KITTITAS COUNTY

DEPARTMENT OF PUBLIC WORKS

MEMORANDUM

TO: All Staff
FROM: Public Works Plan Review Team
DATE: October 18, 2024
SUBJECT: VA-24-00002 Duncckley

## EXHIBIT MAP

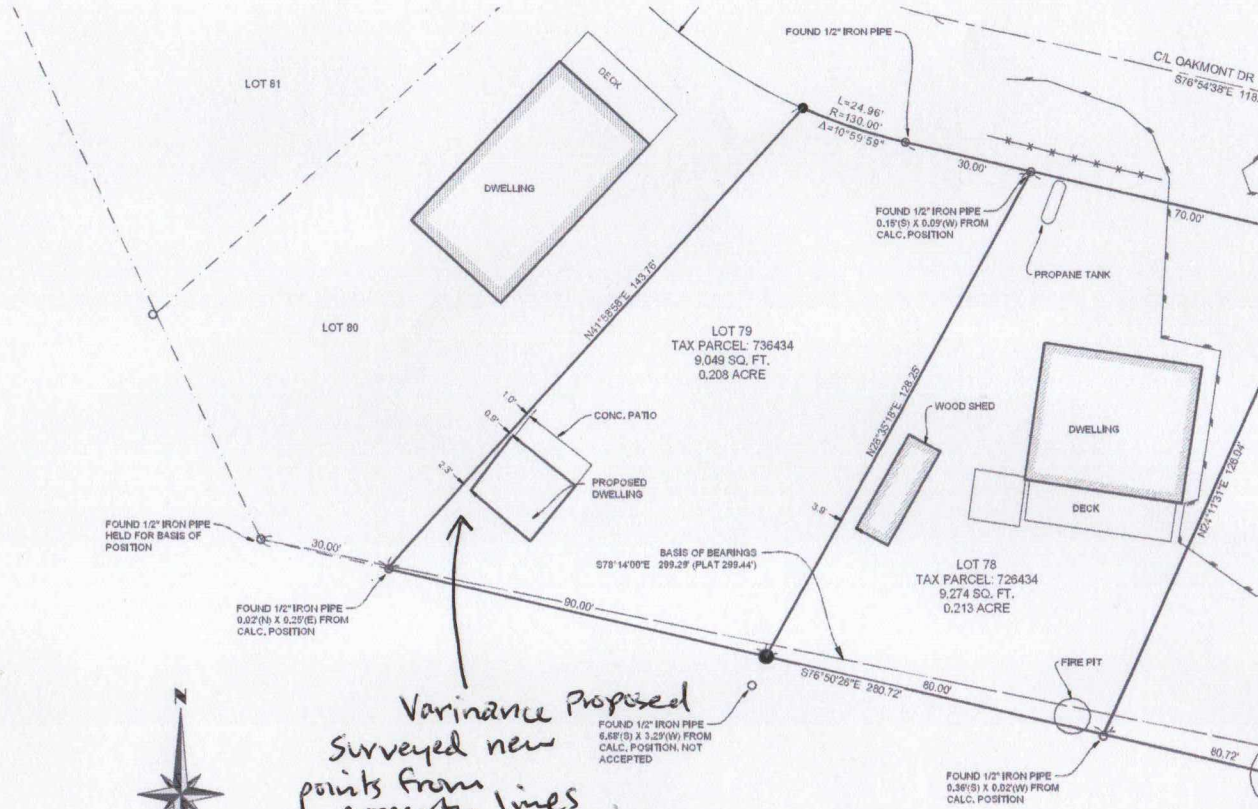
ACCESS	No comments. (JS)
ENGINEERING	Except as exempted in KCC 14.05.060, no grading or filling upon a site involving more than one hundred (100) cubic yards shall be performed without a grading permit from the County Engineer or Public Works designee (KCC 14.05.050). An application for grading in excess of five hundred (500) cubic yards shall be accompanied by an engineered grading plan (KCC 14.05.080). (CP)
SURVEY	With the proposed setback of 0.9' to the property line, there still exists many potential issues that would need to be addressed, including aerial trespass of any eave overhangs, outswinging doors, and even the ability to perform routine maintenance on the structure without trespassing onto the neighboring parcel. I would propose a Boundary Line Adjustment be performed, or the building relocated to meet setback requirements. (JT)
TRANSPORTATION CONCURRENCY	No comments. (JS)
FLOOD	No comments. (SC)
